Subject: Sundown Solar Farm

The Department of Planning, Housing and Infrastructure – Crown Lands has reviewed the submissions report from ERM concerning the proposed Sundown Solar Farm. Crown Lands notes that comments from previous advice have been included (Tables 3.1, 3.3.1, 4.5).

Figure 1. Gwydir Highway / Spring Hill Mountain intersection upgrade

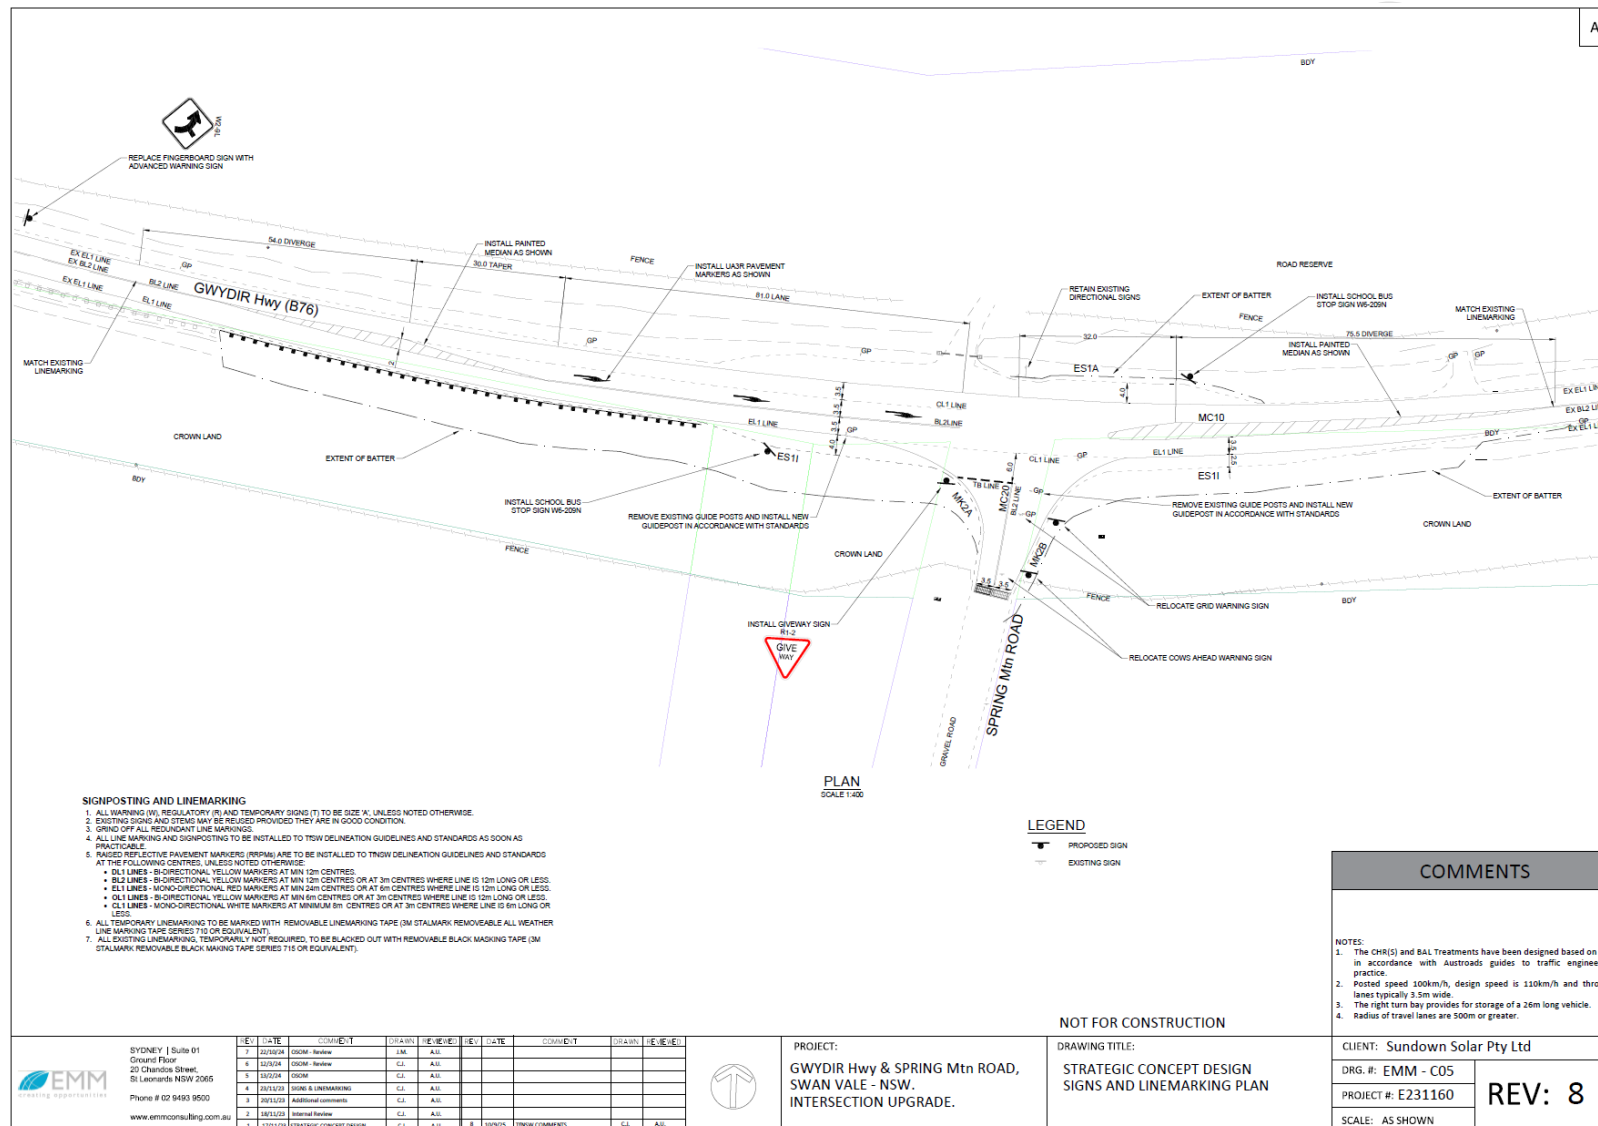
The intersection of Spring Mountain Road and Gwydir Highway has been covered in Table 4.5. The proponent has forwarded further detail of the required expansion of the formed intersection which identifies parts of Crown Reserve 67474 (Lot 7301 DP 1165765, reserved for ‘travelling stock’ and under management of Northern Tablelands Local Land Services). Table 4.5 notes that Crown Lands originally stated that a permit would be required to enable construction where it impinges on the Crown land. Since this advice, Permits are no longer available for Crown Lands to use. Updated information has been supplied to the proponent and is under consideration by the proponent, whereby the recommended course of action is for Transport for NSW and/or Inverell Shire Council to acquire the necessary Crown land to construct the extended road access under the *Land Acquisition (Just Terms Compensation) Act 1991*. Depending on ownership of the adjoining section of road, Crown Lands recommends consultation with both authorities to determine which land should be acquired by which agency.

Being permanent alterations to the road formation that impinges on Crown land, acquisition of the land by Transport for NSW and/or Inverell Council allows these authorities to continue to manage the road formation.

Form temporary access to additional areas of Crown land during movement of two oversize vehicles (transport of transformers), where the land is not required for ongoing road formation, Crown Lands will consider a temporary tenure to be assessed based on disturbance to the site.
